Application Ref: 3/2018/0209
Date Inspected: 26/03/2018
Officer: RB

DELEGATED ITEM FILE REPORT:

Development Description: Conversion of garage to games room and construction of new garage in stone

Site Address/Location: Chalk Hall, Judd Holmes Lane, Chipping, PR3 2TJ

Drawing Title  
**PLANS, SITE PLAN  
 ELEVATIONS**

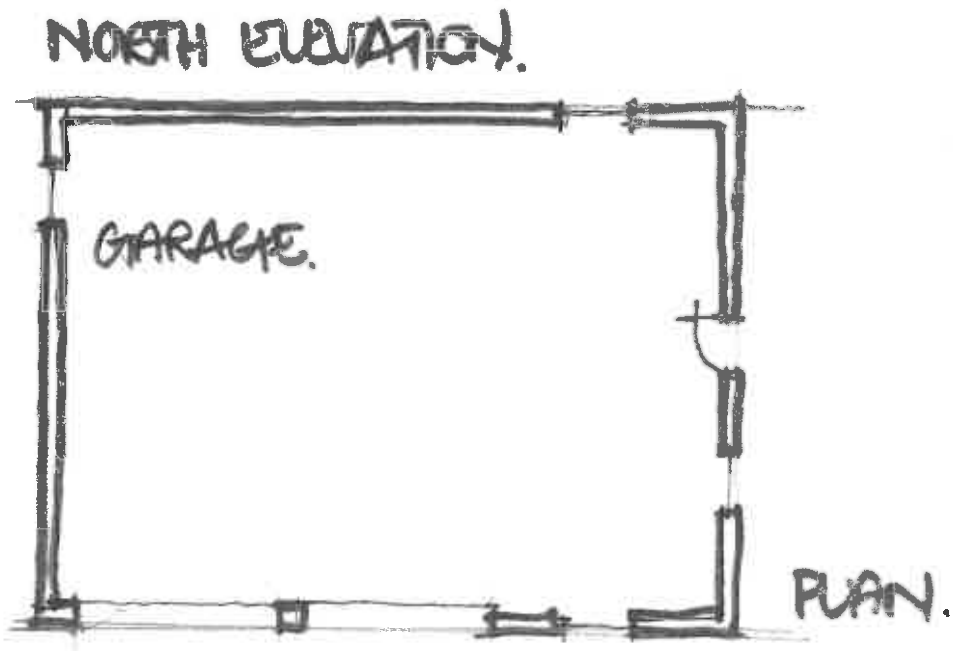
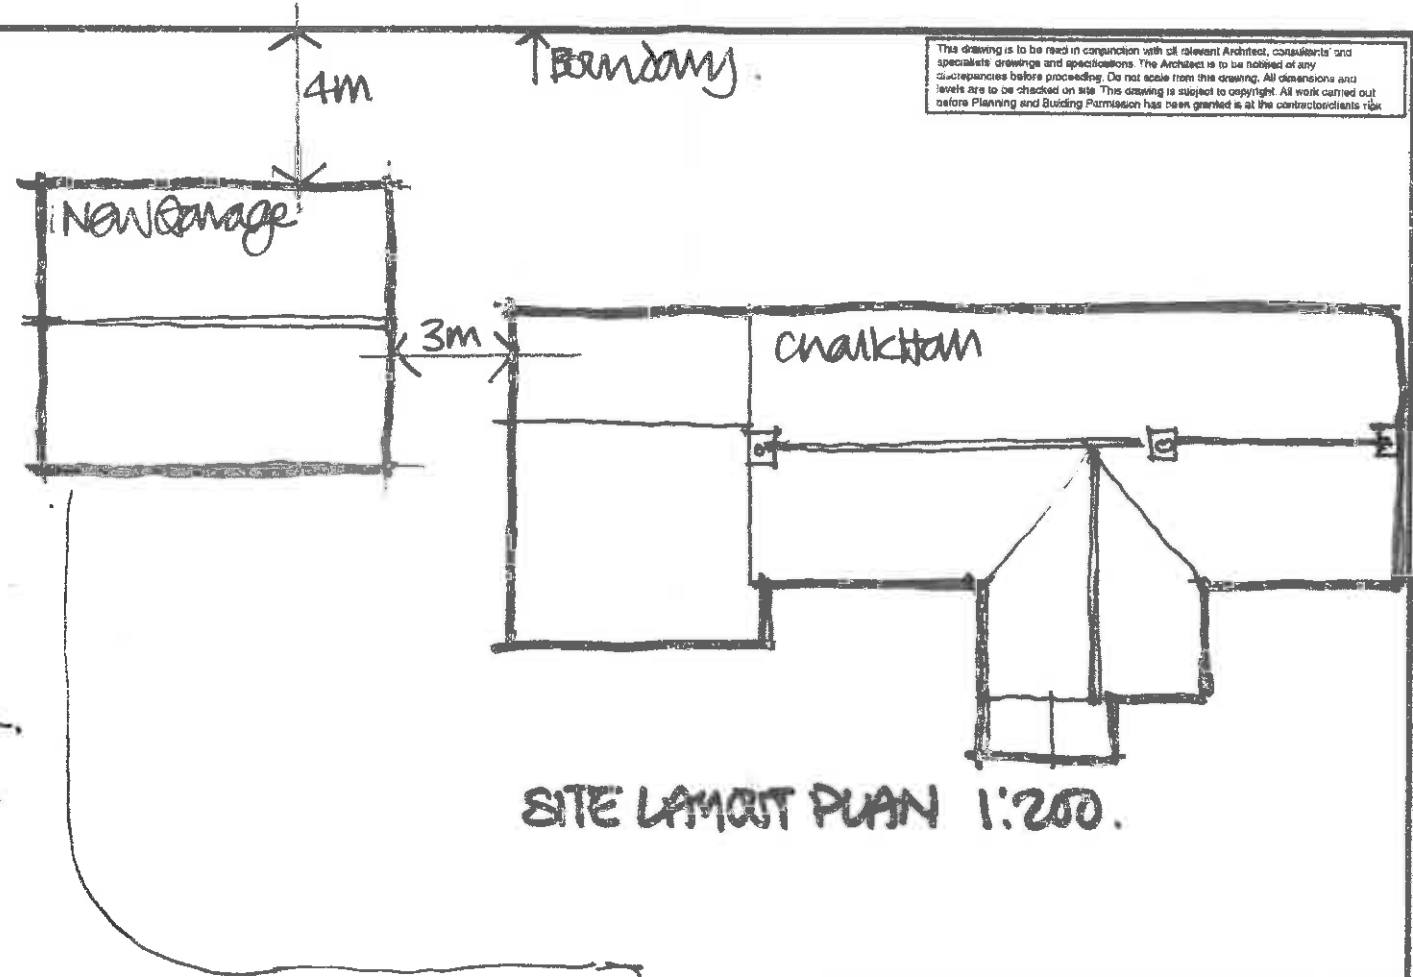
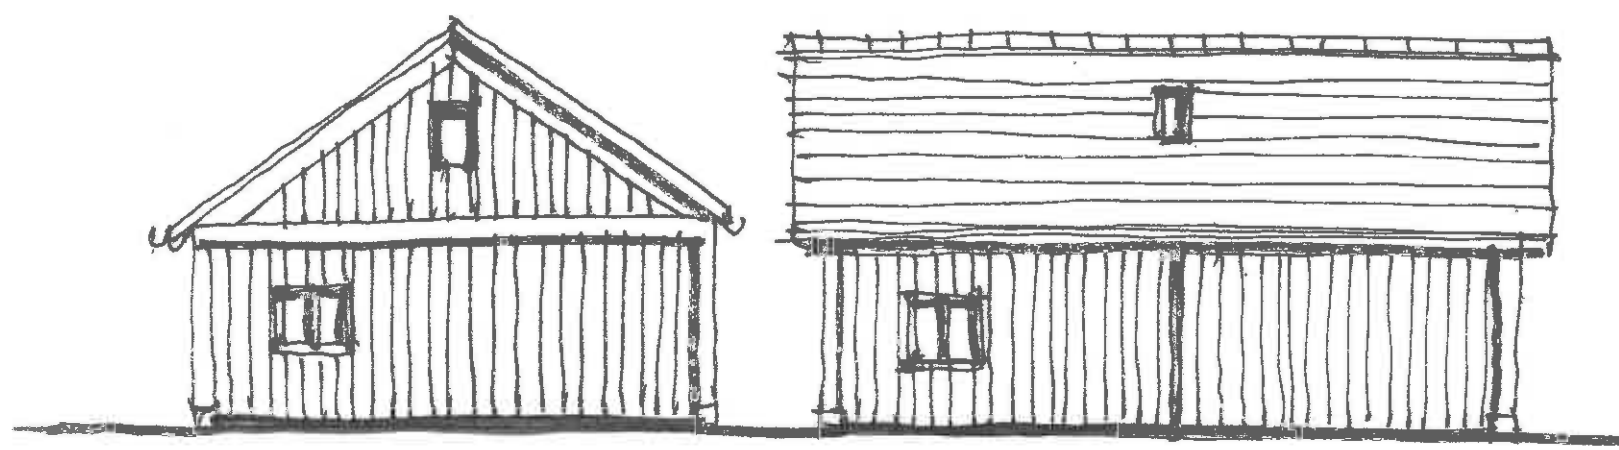
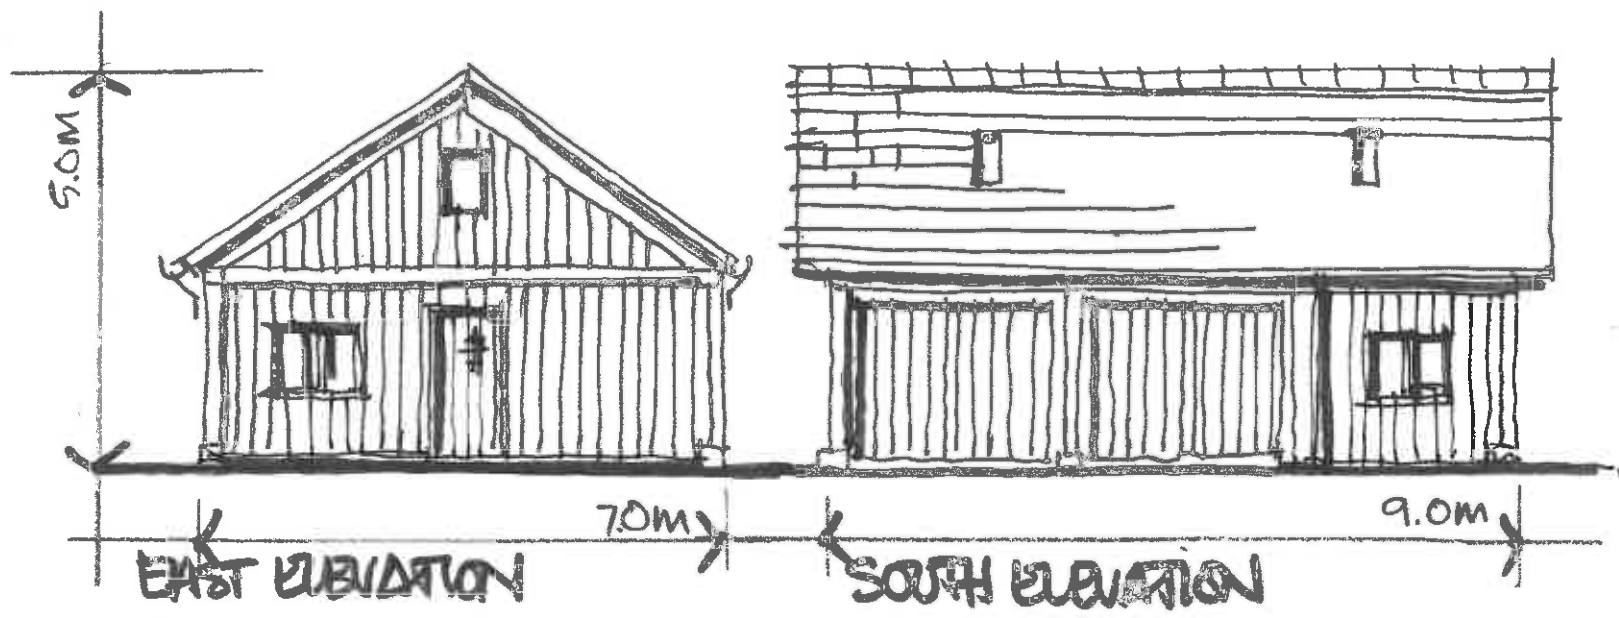
When originally submitted it was proposed that the garage be faced primarily with timber cladding, it was considered that this would cause harm to the AONB and it was requested that the materials be more in keeping with the existing dwelling. The agent subsequently sent amended plans that indicate the use of stone and blue slate.
